WILPSHIRE PARISH COUNCIL

3/2012/0390 Land between 52 & 54 Knowsley Road, Wilpshire

Wilpshire Parish Council object to the above application for the following reasons:

PAPER SIZE:	DRAWING NUMBER:	REV
A1	BS-08-076-02	E
SCALE:	DATE:	DRAWN BY:
1/100	October 2011	GM

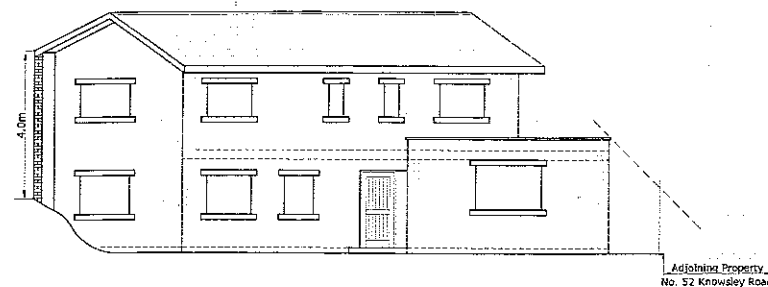
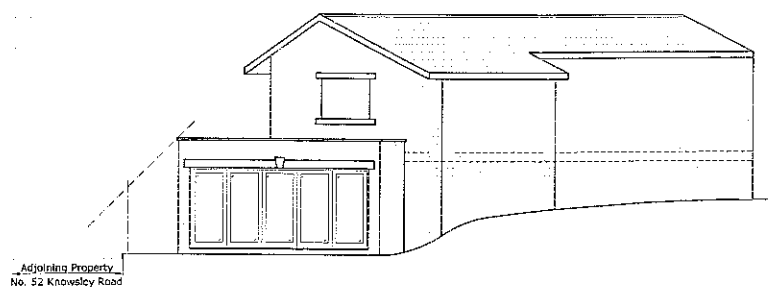
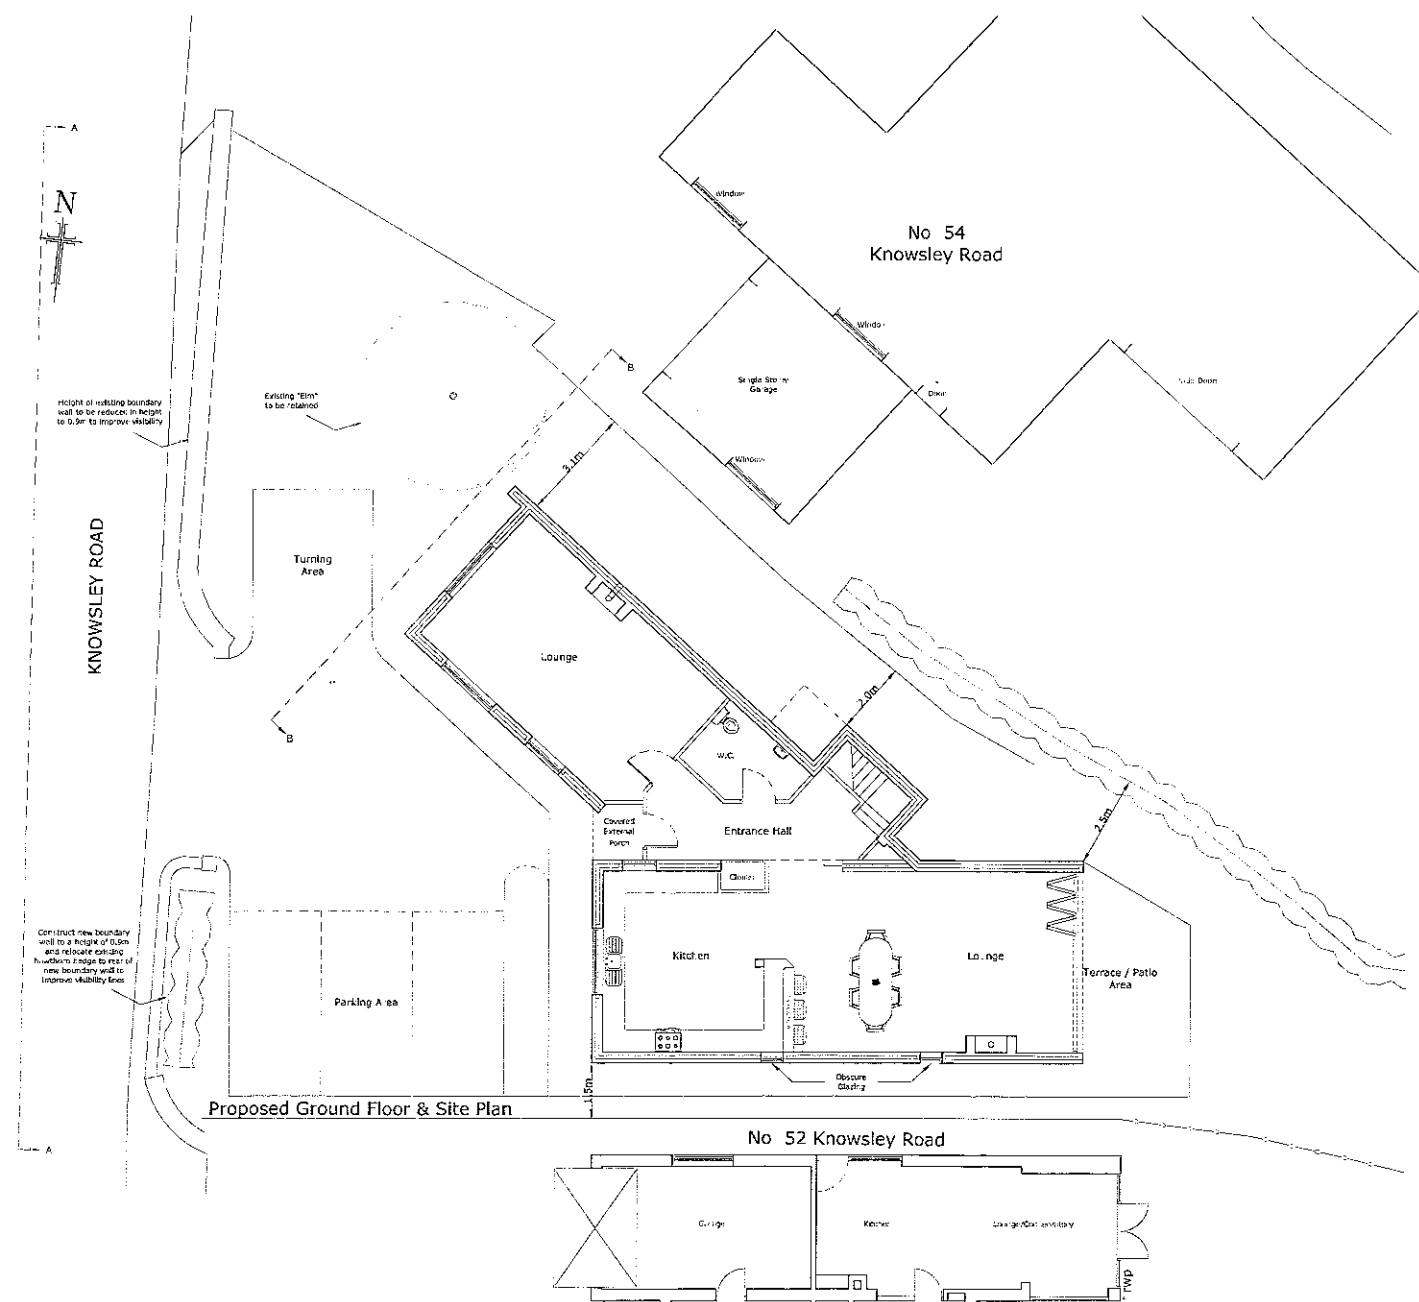
Loss of amenity to neighbouring properties
Loss of light to neighbouring property
Going beyond the building line
Impact on street scene and massing
